REF NO: Y/15/17/DOC

LOCATION: Land to the North of John Turner Phormiums, Lake Lane, Barnham, PO22 0AL

PROPOSAL: Application for approval of details reserved by condition imposed under Y/64/16/PL relating to conditions 5-landscape scheme for HGV parking site, 6-landscape scheme along southern boundary, 7-Site Management Plan & 10-light appliances.

DPN0868 - REV B

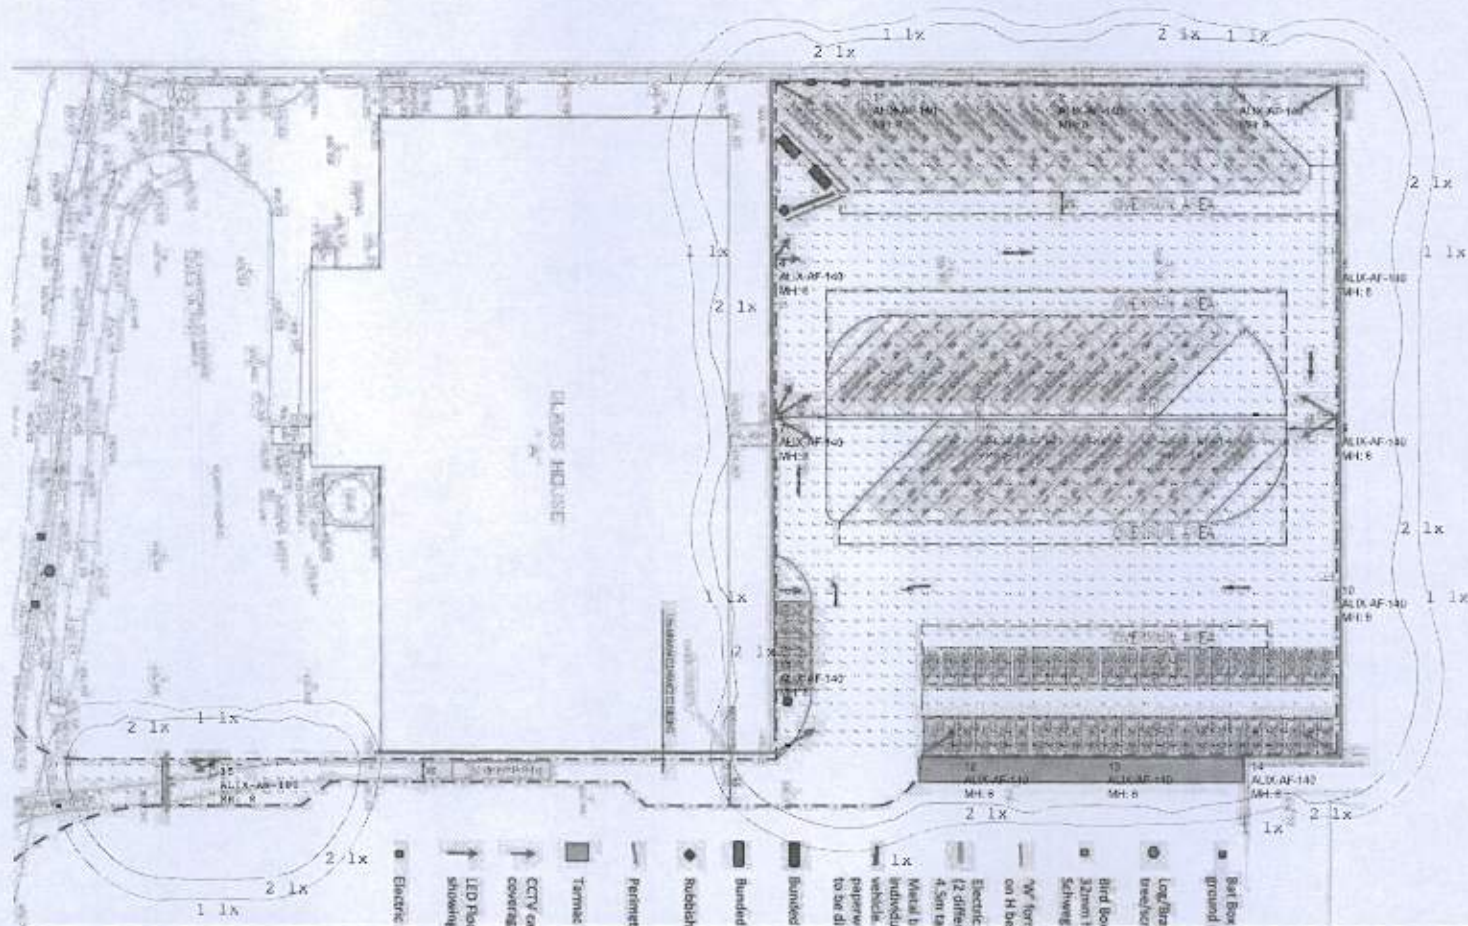
The only representation made which refers to lighting on the new site is (16), that lighting is unacceptable in this rural location. This is noted, however, the proposed lighting has already been granted in principle by the associated planning application. The condition was imposed in order to minimise light pollution generally but particularly in respect of bats in the area of the site.

The Council's ecologist has appraised the impact of the lighting scheme on local bat populations and raises no objection. In addition, Environmental Health officers raise no concerns from a general amenity point of view. It is therefore recommended that this condition be discharged.

The detail submitted in respect of the external lighting namely the Exterior Lighting Layout Plan ref DPN0868 Rev B and the accompanying ALIx LED Outdoor Luminaire product information sheets have been appraised by the Councils Ecologists and Environmental Health Officers and is considered to be acceptable and satisfies the requirements of the condition. The condition is therefore fully discharged on the understanding that you will implement the lighting in accordance with the approved details.

Arbtech LP 01

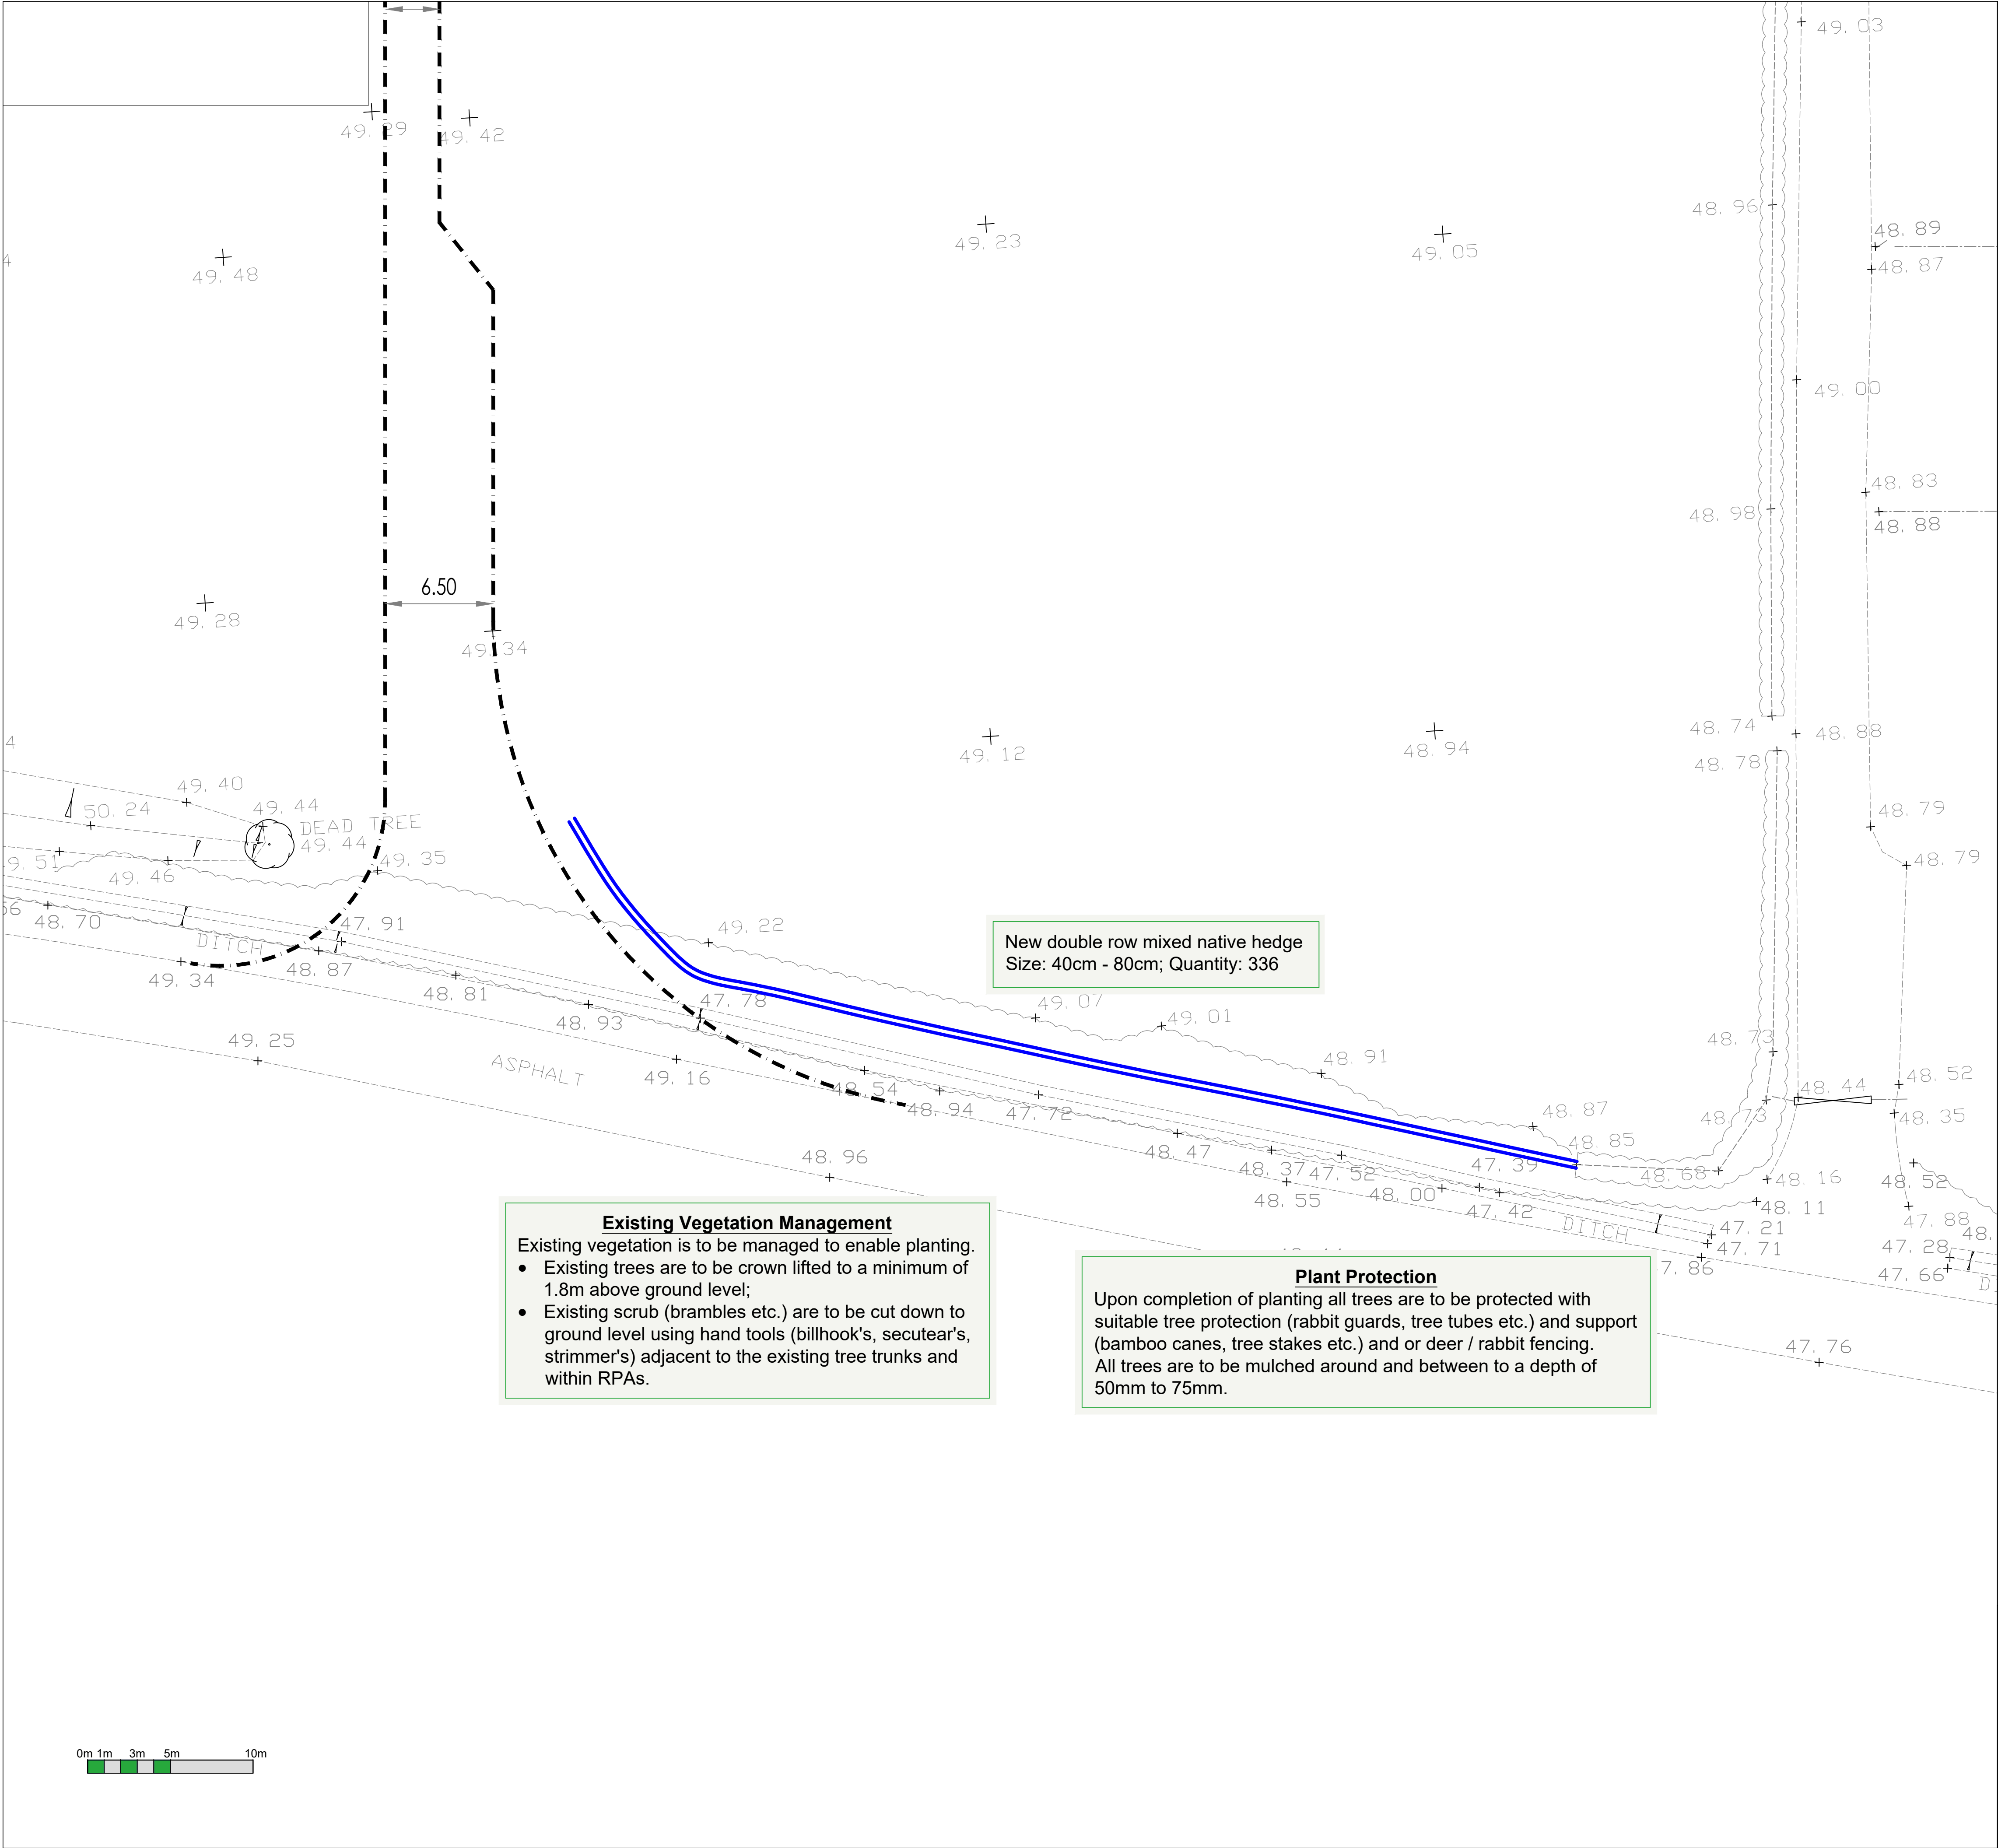
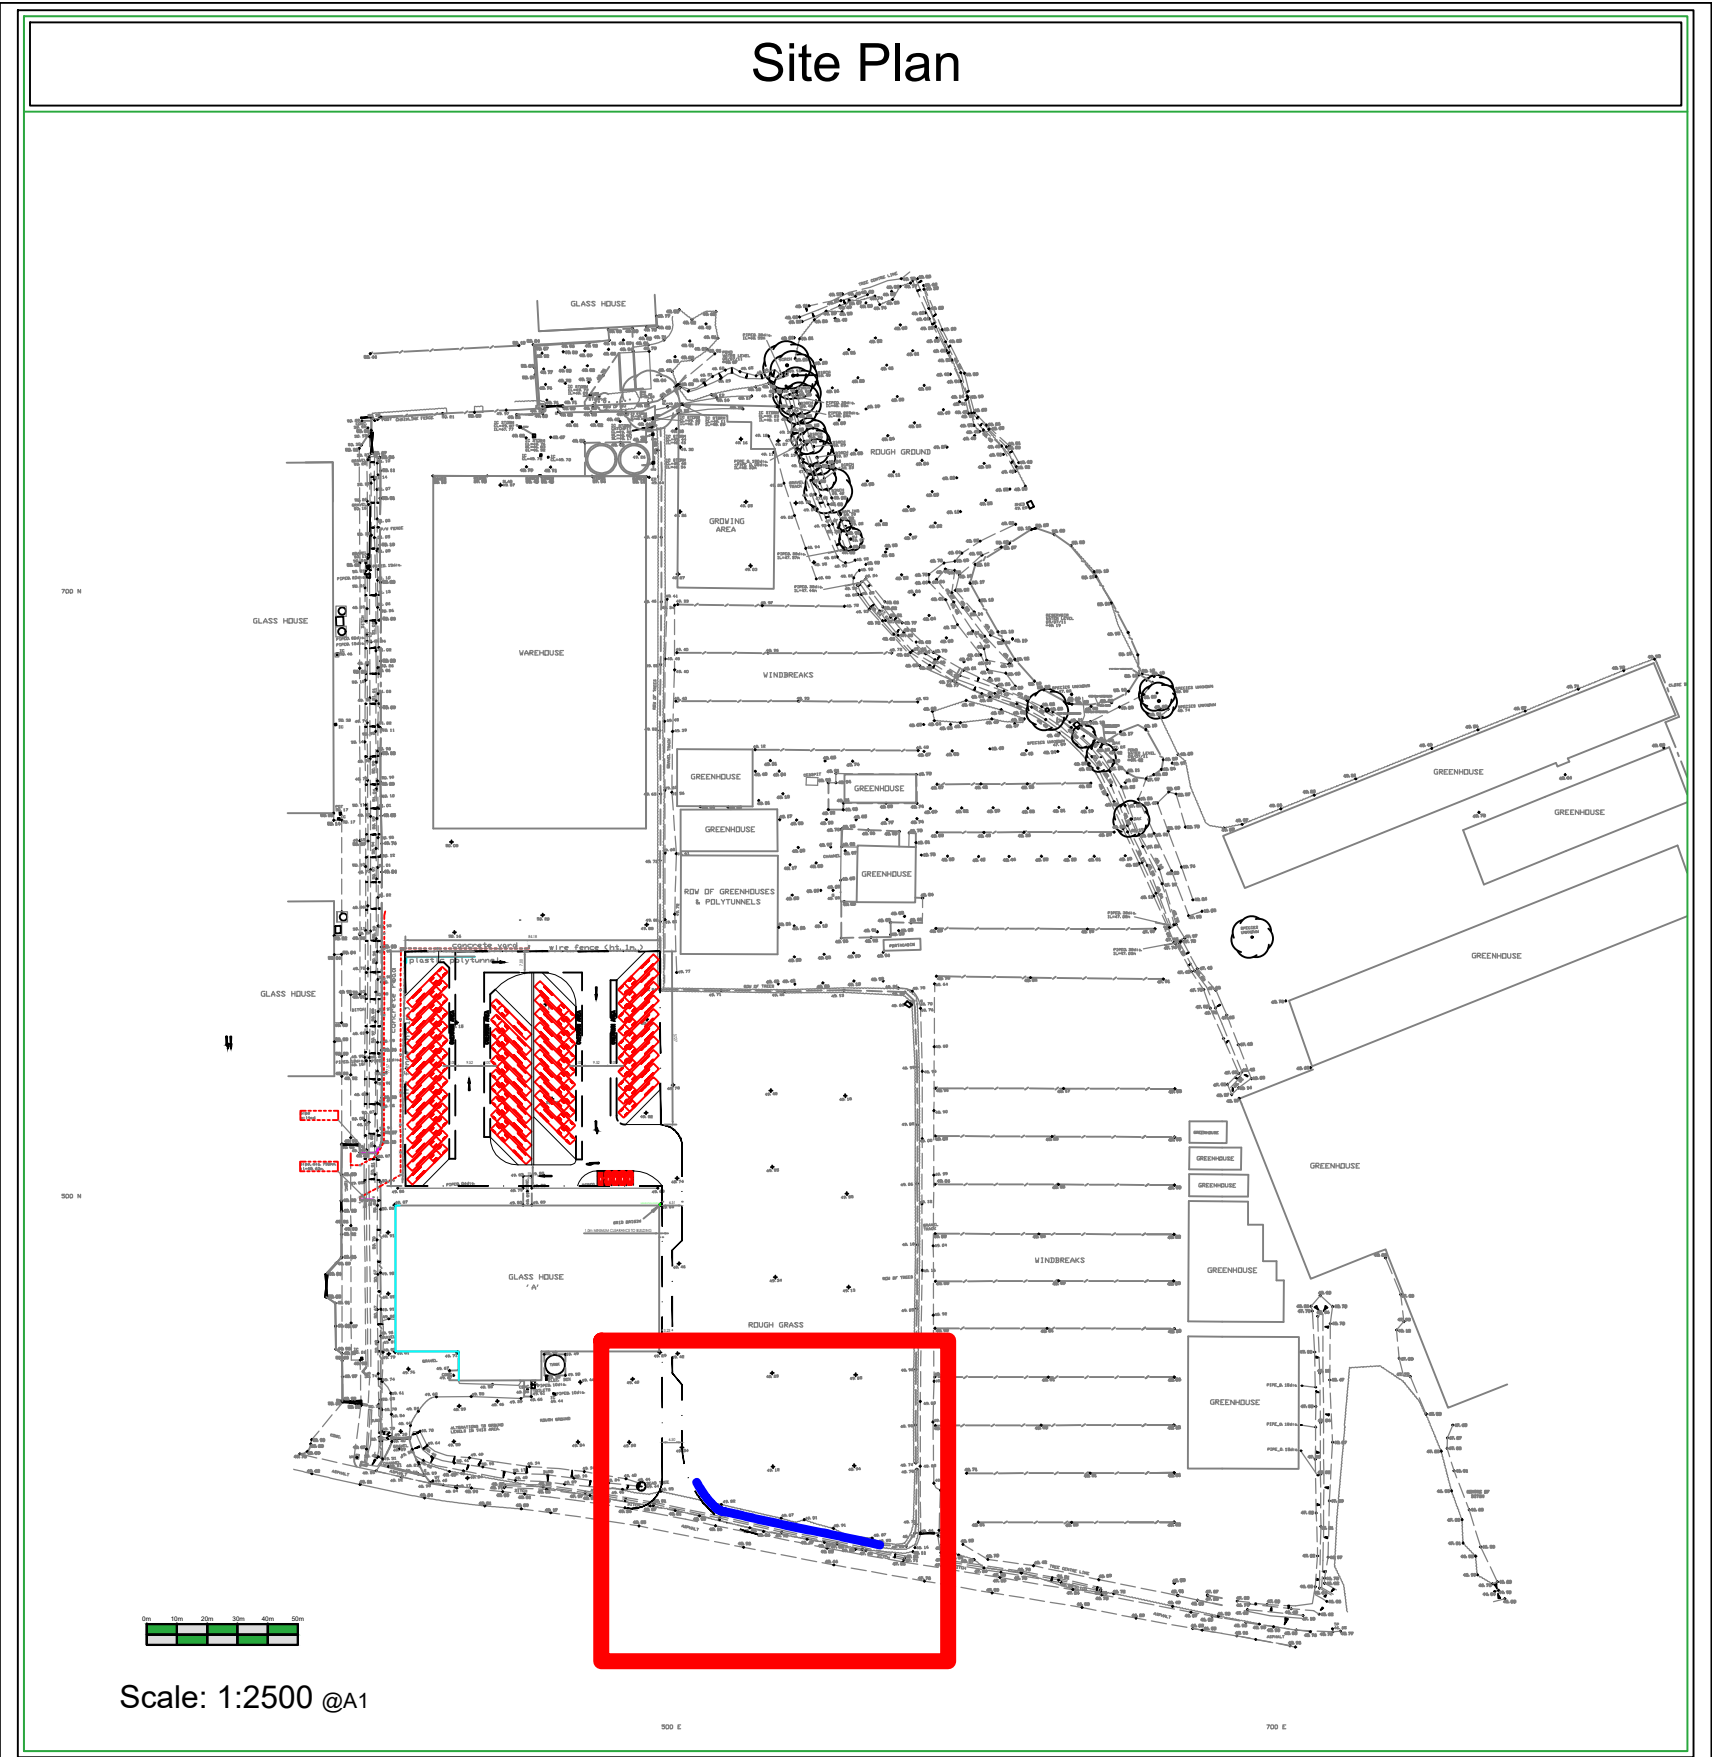
The only representation made which refers to landscaping on this site is (13) - no detail as to how many trees or their age at which time they are planted. This comment was received prior to the submission of a more detailed Landscaping Plan which has now been agreed by the Councils Landscape Officer. In addition, the Council's ecologist raises no objection to the proposed mix of planting species. It is therefore recommended that this condition be discharged.

The submitted Landscape Scheme as detailed on Drawing Arbtech LP01 (June 2017) as supplemented by the Arbtech Report (02/03/17) has been assessed by our Landscape Officer and is considered to be acceptable.
